CITY OF PORTLAND BUILDING PERMIT

PERMIT ID: 2013-00319

has permission to **Phase 2 - Repair and replace brick facade, knee walls, steel bumpers, and barrier cables**

City of Portland, Maine - Building or Use Permit

FORE STREET PARKING FACILITY  
PORTLAND, ME  
FACADE REPAIRS PHASE 2  
BARRIER CABLE DETAILS

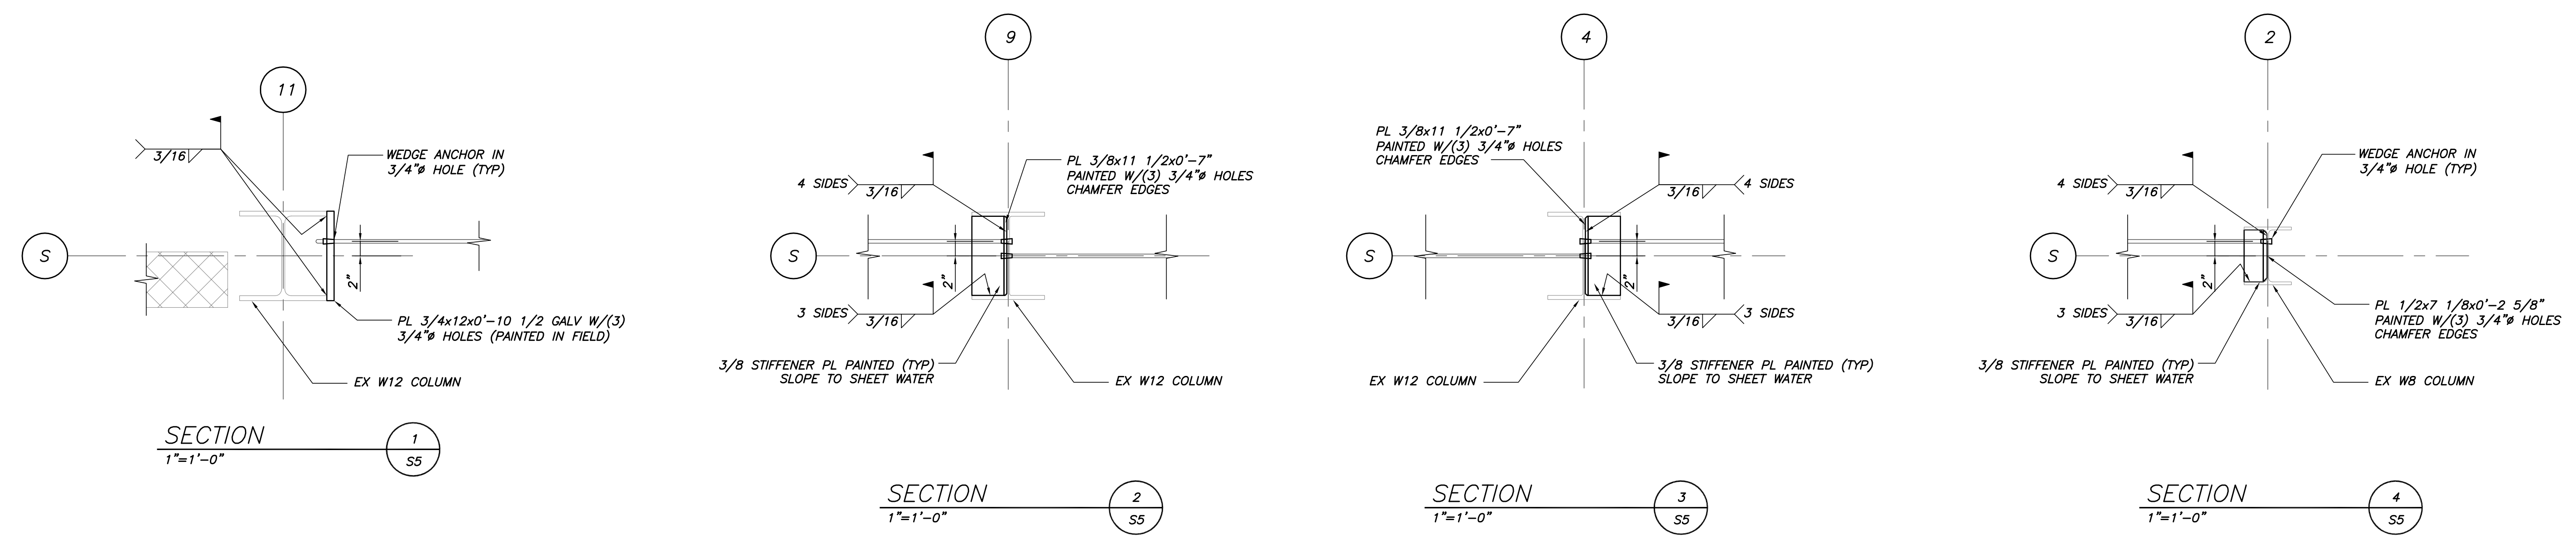
- 3) Permit approved based on the plans submitted and reviewed w/owner/ contractor, with additional information as agreed on and as noted on plans.
- 4) 406.2.3 Guards. Guards shall be provided in accordance with Section 1013. Guards serving as vehicle barrier systems shall comply with Sections 406.2.4 and 1013.
- 5) 406.2.4 Vehicle barrier systems. Vehicle barrier systems not less than 2 feet 9 inches high shall be placed at the end of drive lanes, and at the end of parking spaces where the vertical distance to the ground or surface directly below is greater than 1 foot. Vehicle barrier systems shall comply with the loading requirements of Section 1607.7.3.
